From: John Green
Sent: 26 September 2008 09:54
To: Planning.Responses
Subject: RE: Planning Consultation on: LU/257/08/

APPLICATION NO: LU/257/08/

Registered: 08-SEP-08
Site Address: 26 High Street Littlehampton

Description of Works: Change of use from offices to ground floor restaurant and first and second floor flats.

PROPOSED GROUND FLOOR PLAN

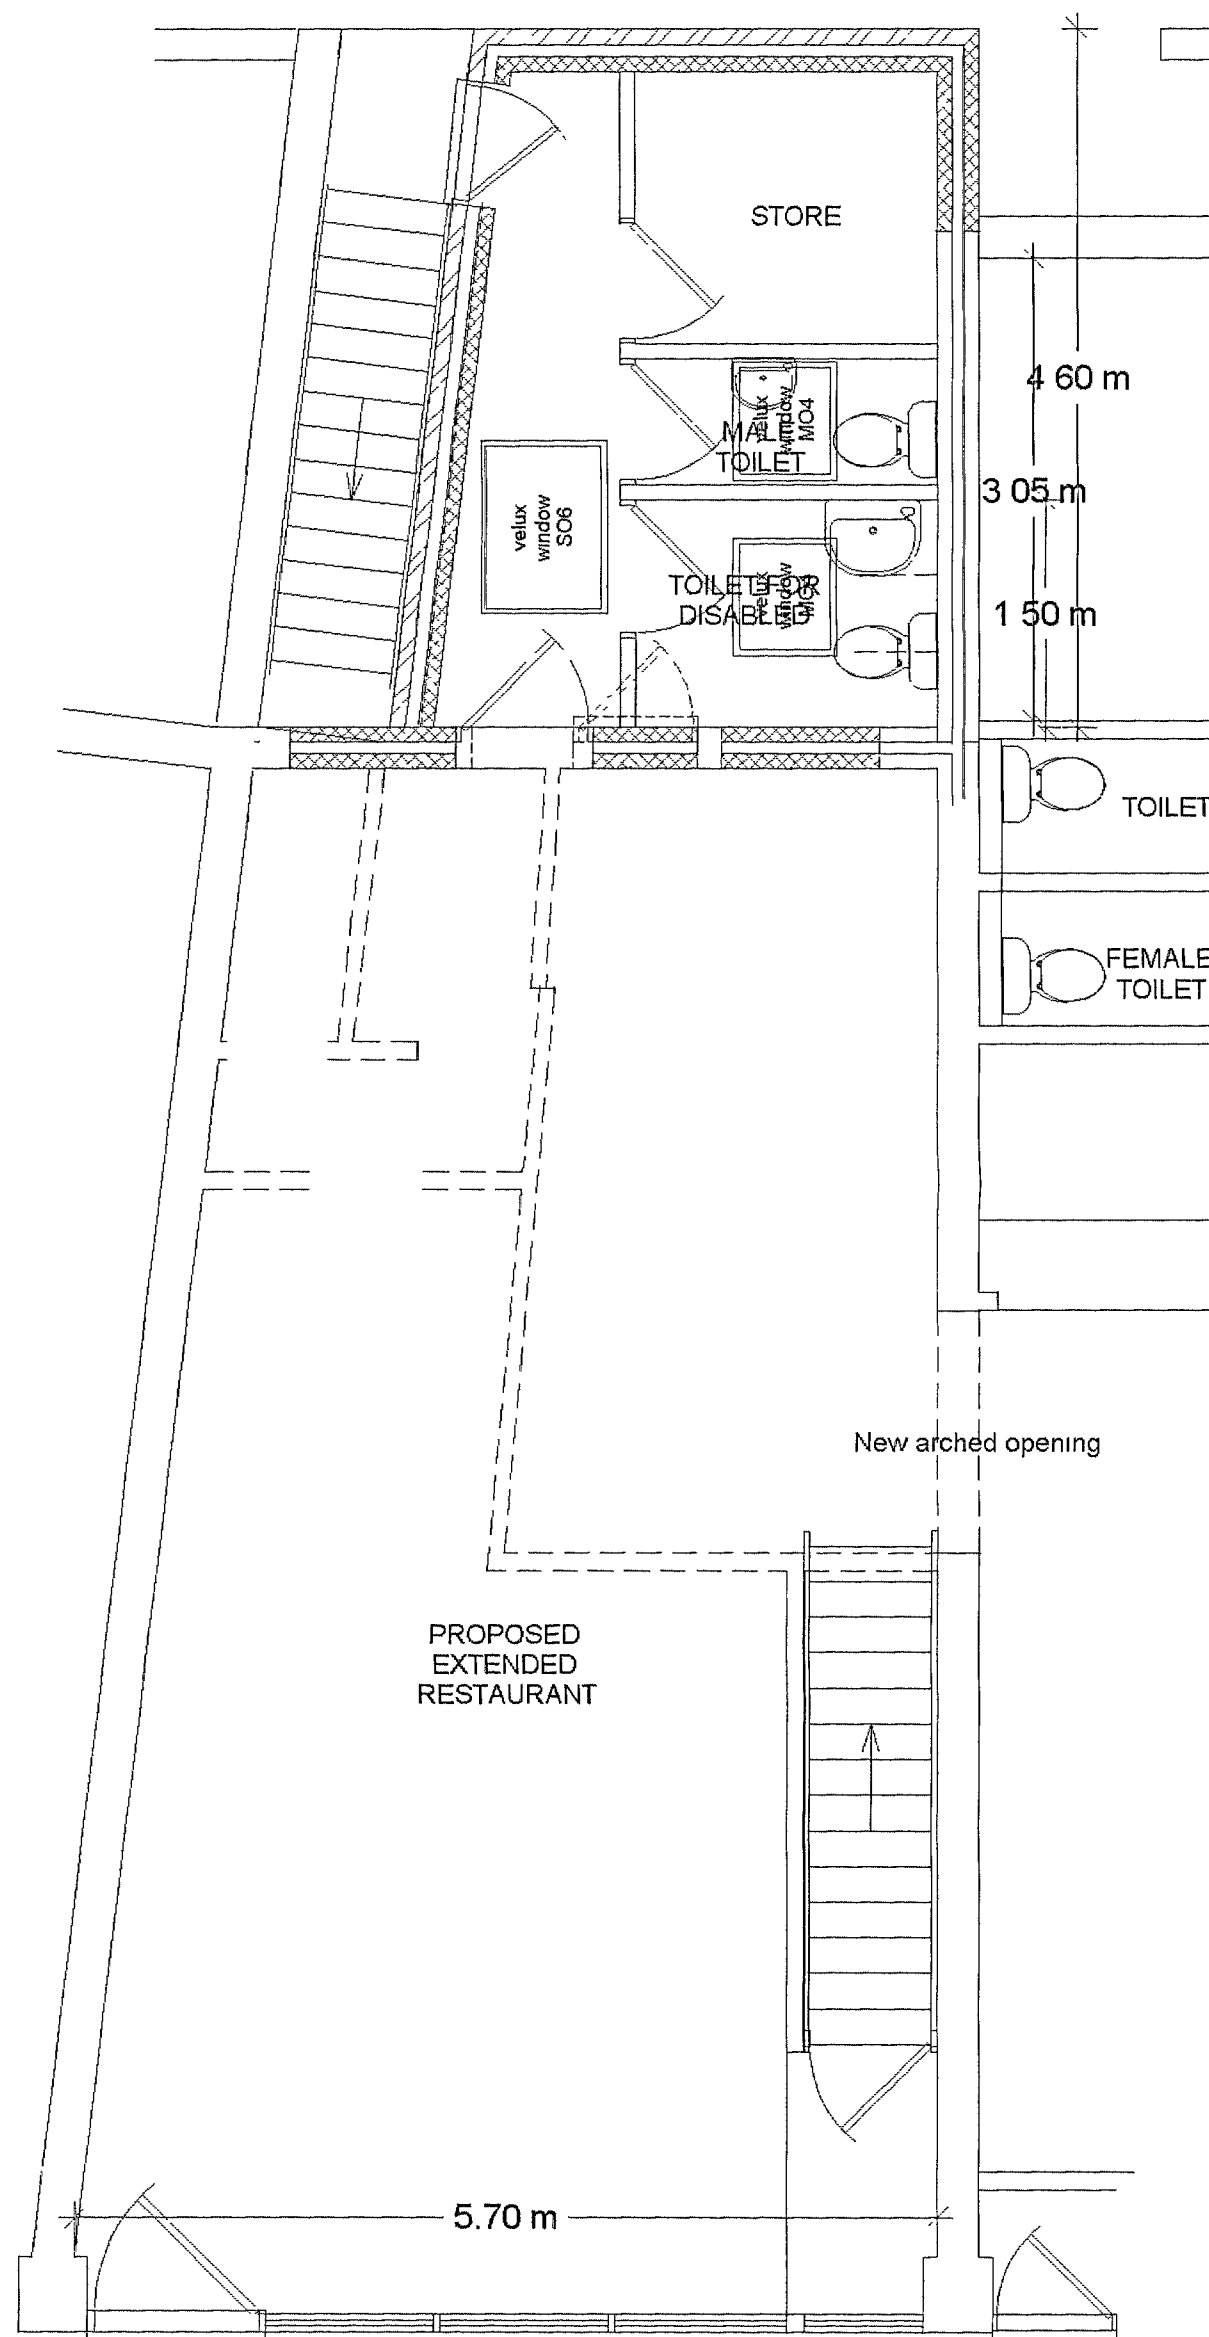
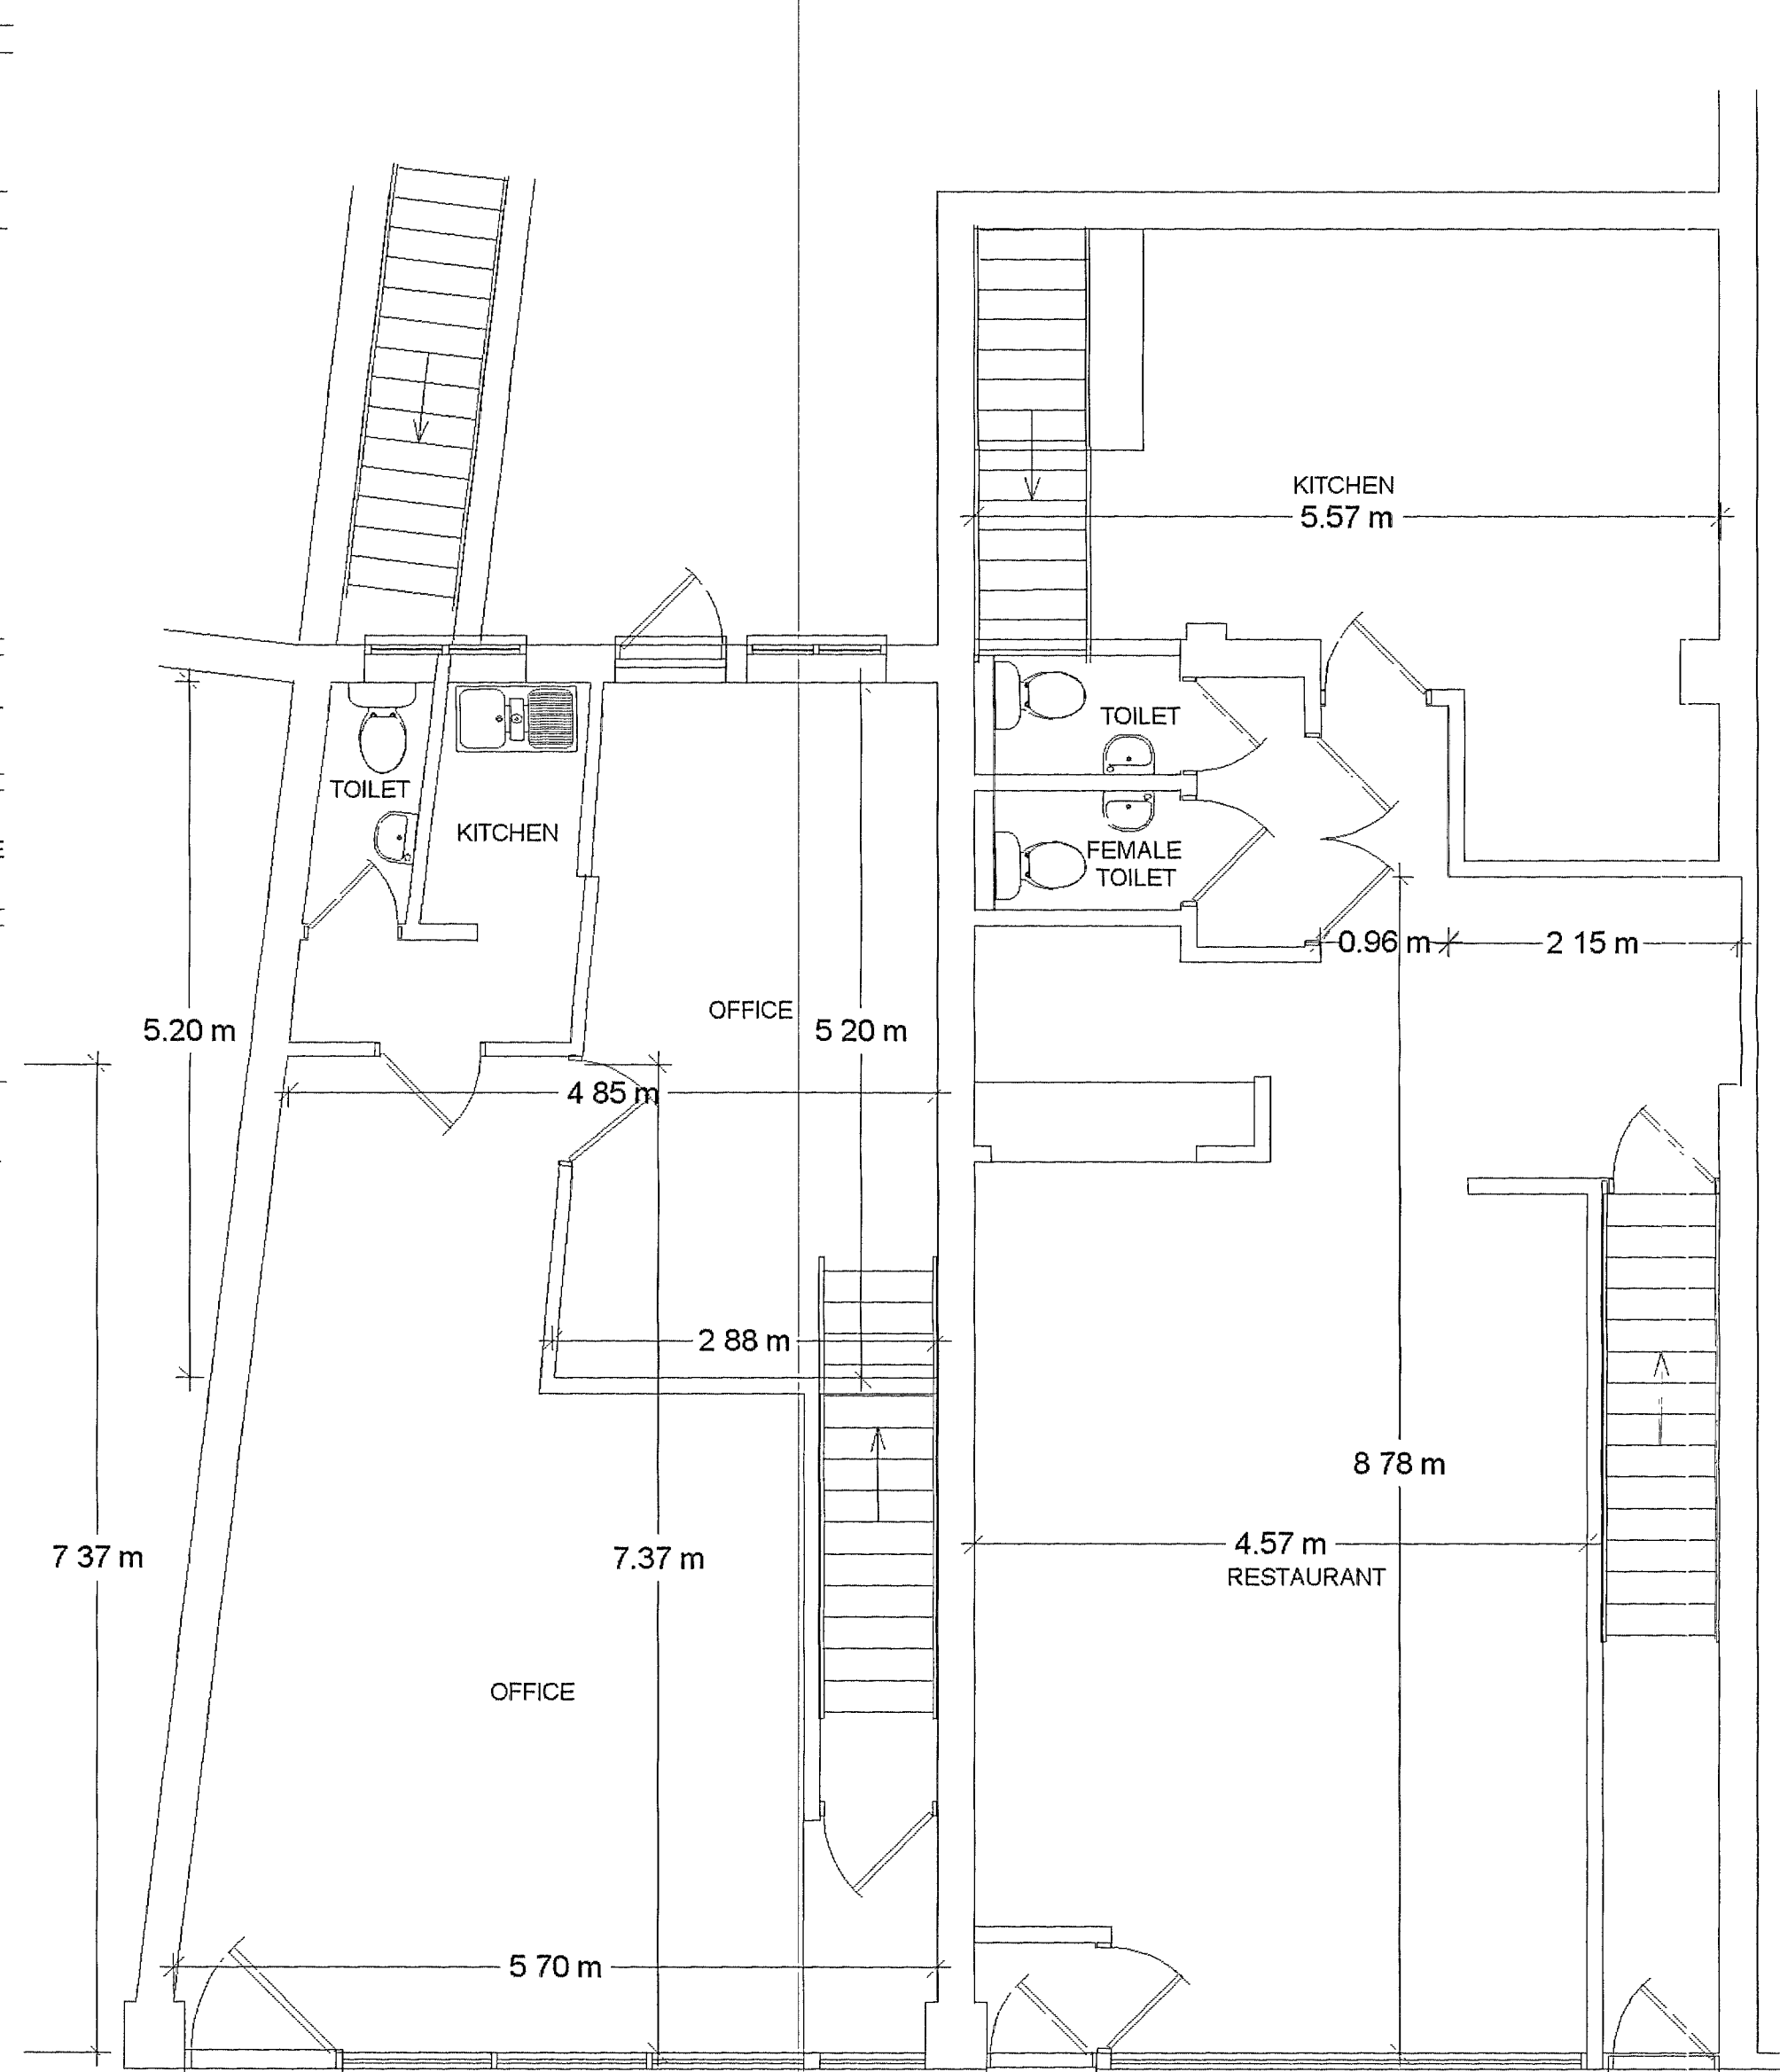
The proposal for 'added' seating to existing restaurant is noted, but no proposal for increased food preparation facilities or cooking capacity in proportion to higher customer no's. New 'store' situated are rear of new toilets, in extension, is accessed through toilet lobby, which is not acceptable if used as a food storeroom.

Increased cooking for additional customers, could result in increased odour/noise emissions, has applicant any proposals for ventilation upgrade or additional control measures. I cannot support this application as these proposals are a missed opportunity to increase the capacity of the current limited food production and food storage areas for both premises, which could be achieved by a layout change and direct attachment to the current kitchen at No.24.
